RESPONSE TO SUBMISSIONS - Section 96(1a) amendment to SSD 14 6387 at 1 Burroway Road, Wentworth Point

This letter provides a response to the issues raised by the Department of Planning and Environment, Sydney Olympic Park Authority and the City of Parramatta in response to a Section 96(1a) proposal to modify Development Consent SSD 6387 for a mixed use development at 1 Burroway Road, Wentworth Point to provide a canopy structure over the central open air plaza area as well as the addition of a small café at the southern end of the central open air plaza.

DRAWING NUMBER
DA 1201

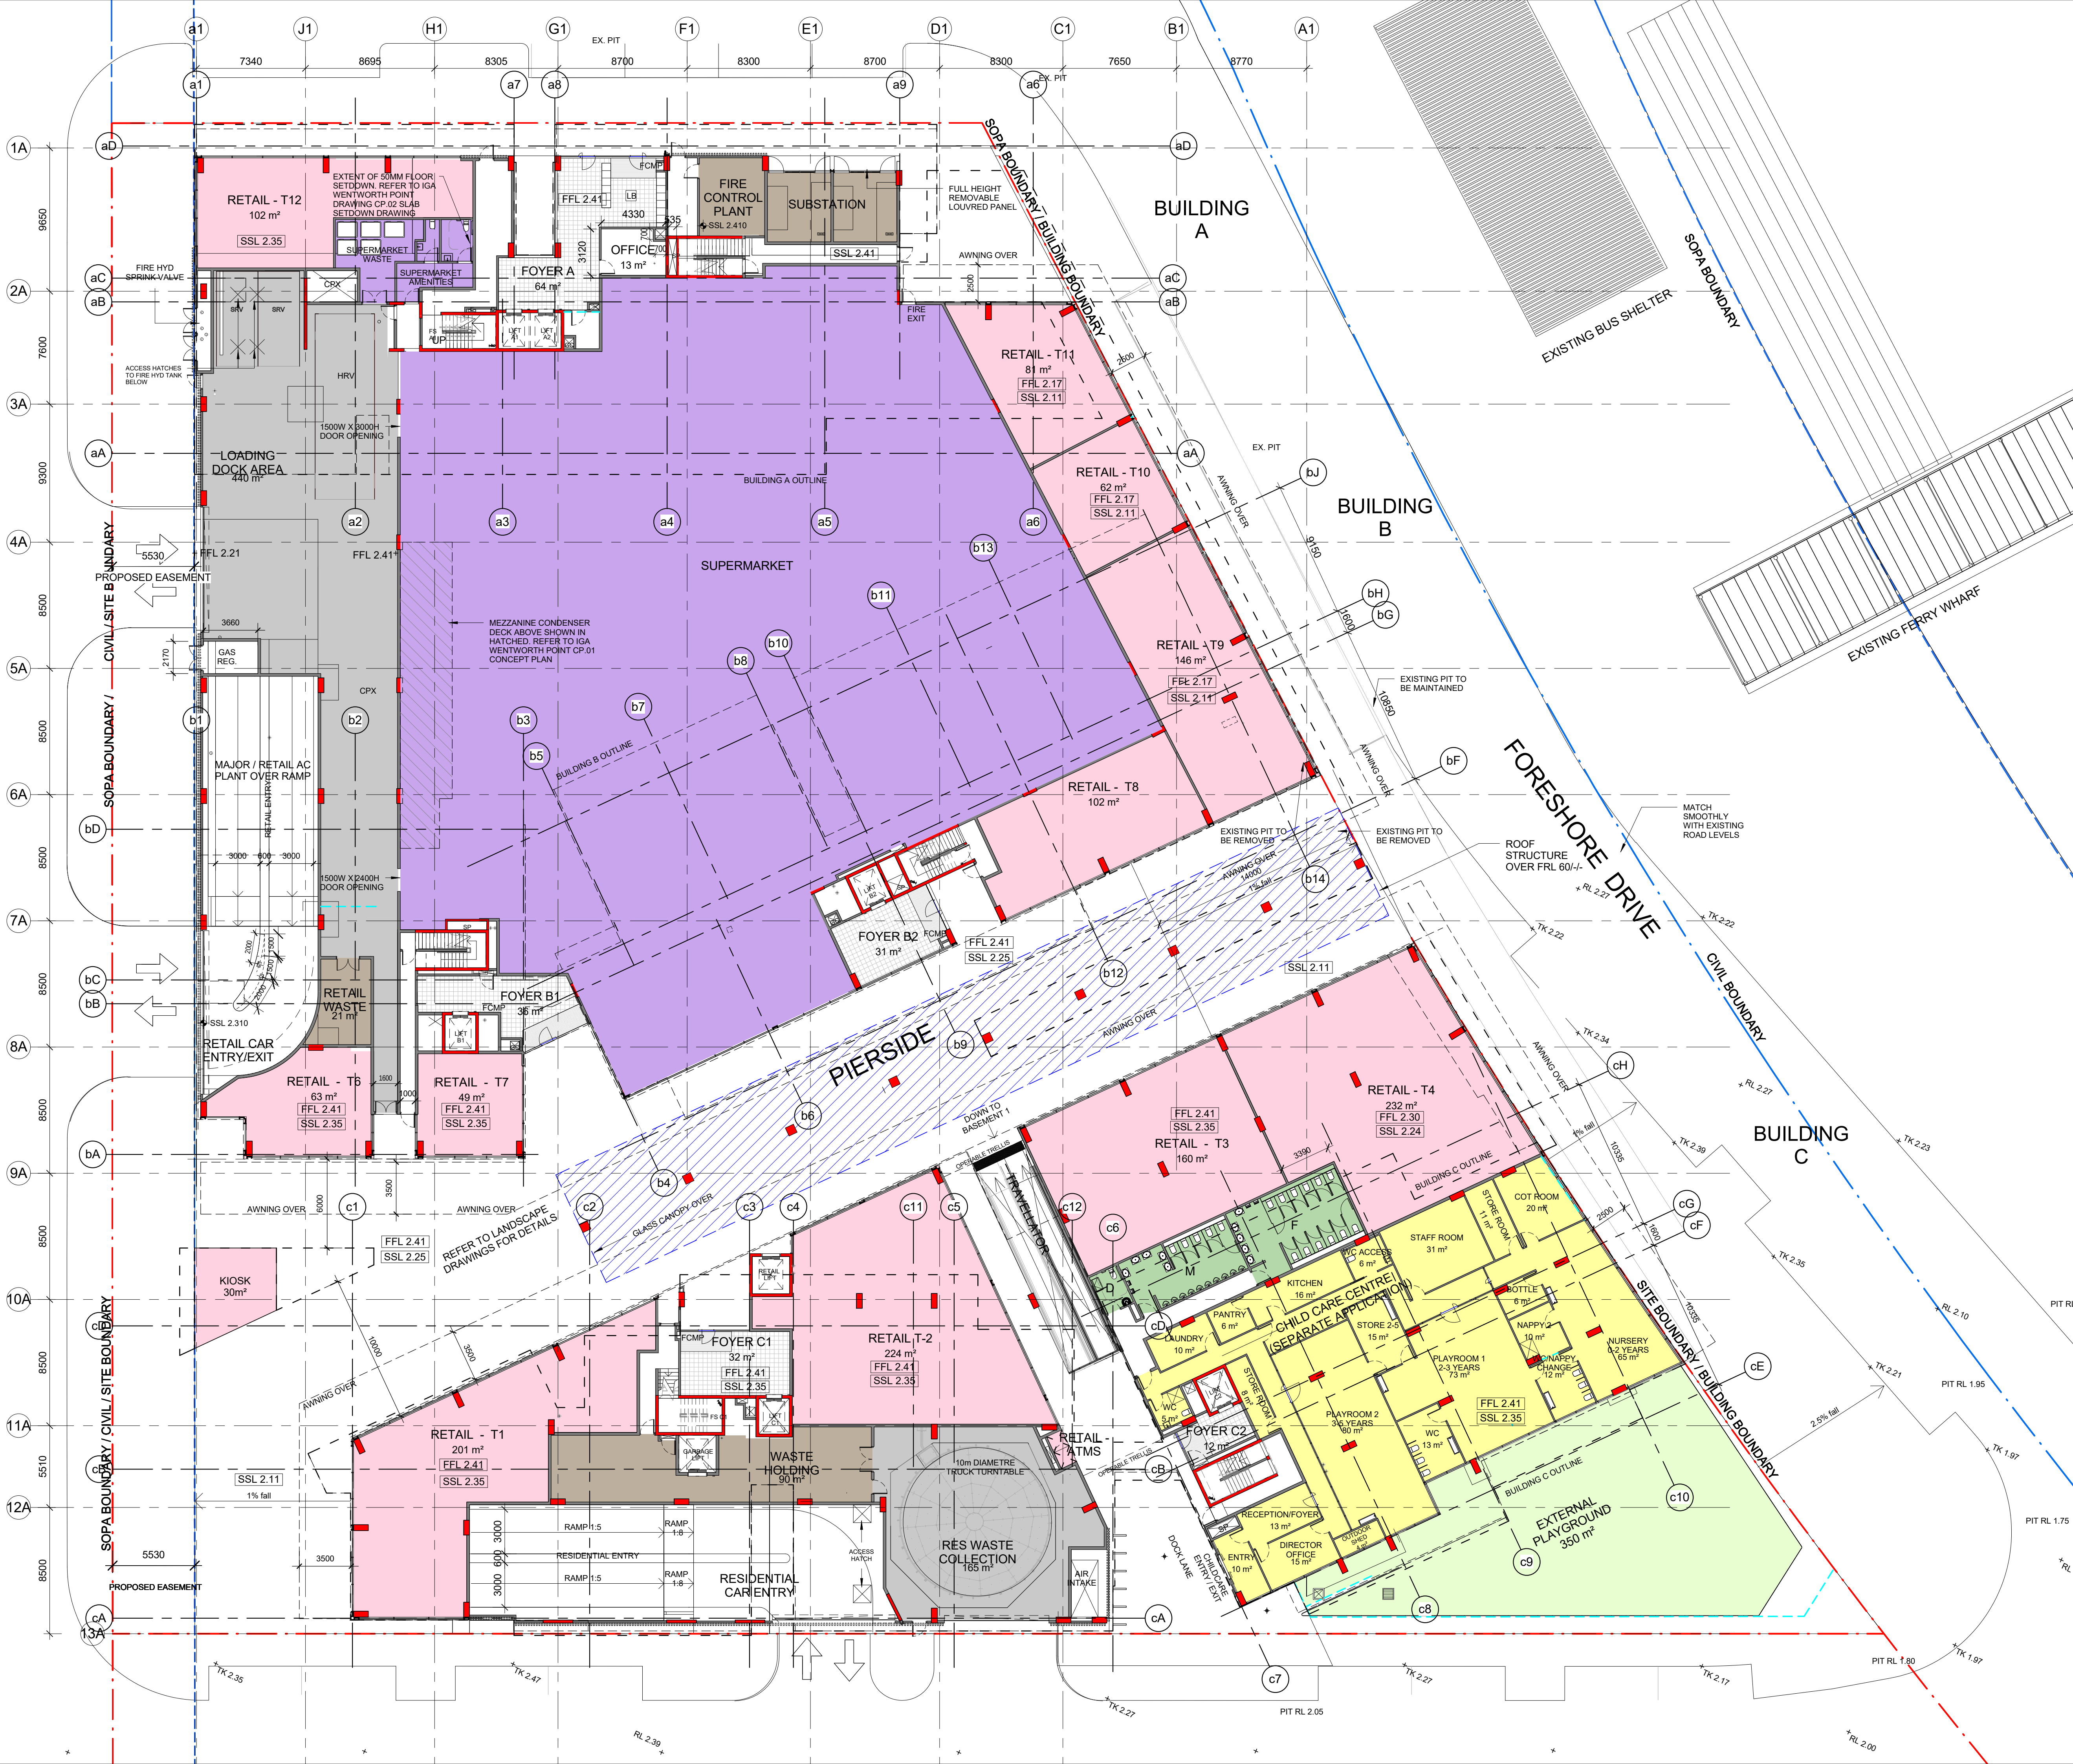
Issue	Response
<ul style="list-style-type: none"> the current proportions of the proposed cafe are considered to be excessive and should be reduced to a maximum area of 20m². 	 <p>Given that the amended location and size of the café provides the required 10 metre wide through-site link, there is no further basis to warrant a reduction in size to 20 square metres. In particular, it is reiterated that the proposed 30 square metre café will result in a minor increase in the gross floor area to 27,302 square metres and an FSR of 2.62:1 which remains lower than the originally approved gross floor area of the development. Accordingly, the proposed density is within the environmental capacity of the site which has previously been considered to be acceptable by the Department.</p>
City of Parramatta Council	
<p>Proposed Canopy</p> <p>No significant concerns are raised, however it is noted that details of the location of supporting structures have not been provided. In this regard, sufficient pedestrian movement should be maintained throughout the plaza area and appropriate access for people with disabilities will need to be achieved</p>	<p>The canopy is illustrated as being supported by a single row of columns centrally within the through-site link. Given the generous width of the through site link, which is in excess of the minimum required width in the location where the canopy is proposed, it is not considered to result in any meaningful impediment for people with disabilities and in fact provides improved amenity for all pedestrians.</p>

<p>Proposed Café</p> <p>Significant concern is raised with the proposed location of this café. It is a single high structure standing at 3.8m high. It is located at the southern end of the plaza and impedes the visual connection from Burroway Road through the plaza towards the water and the ferry terminal. It also utilises an area which is the gateway to the plaza and impacts upon pedestrian usage (including impeding pedestrian flow). The pedestrian entry to the ferry terminal needs to be clearly defined within the streetscape. It is considered that whilst a café may be an appropriate use within the development site, it should be contained within the ground floor retail component of the development, and not encroach on pedestrian areas. With respect to the above, it is considered that the proposed location of the café does</p>	<p>The proposal has been amended to reduce the café to 30 square metres in area as well as offsetting the café from the through site link in order to maintain a 10 metre dimension for the entirety of the through site link.</p> <p>Therefore, the concerns in relation to visual permeability have been adequately resolved. Furthermore, the café is considered to achieve an important function of activating this gateway area at the entrance to the site which is critical to avoid this large area becoming a sterile space which fails to properly engage with Burroway Road.</p> <p>The amended location of the café complies with the 5 metre setback requirement from Burroway Road and the 10 metre required width of the through site link as prescribed by the SOP Master Plan 2030. The</p>

This correspondence is accompanied by amended architectural plans as a response to the issues which have been raised. The amended configuration has reduced the size of the proposed café to 30 square metres and has relocated the cafe so that it is no longer within the primary through-site link.

Issue	Response
<p>not provide for an appropriate urban design outcome for the public domain.</p> <p>It is noted that within the Secretary's Environmental Assessment Report for the original application that the SOP Master Plan 2030 applied to the site. It appears that the proposed modification (for the café component) would not comply with the setback and through site link requirements of this master plan. The assessment report also acknowledges the "proposed pedestrian through-site link ... provides direct and obvious access to the adjacent ferry and bus interchange in accordance with SOP Masterplan" which appears to justify the non-compliance with setbacks in the original approval. It is therefore considered that the integrity of the Burroway Road setback and provision of the through site link would be further compromised and contrary to the assessment of the original approval. In this regard, it is considered that the location of the café would not allow for the direct and obvious access to the ferry and bus interchange.</p>	<p>amended location of the café allows for direct and obvious access to the ferry and bus interchange.</p>
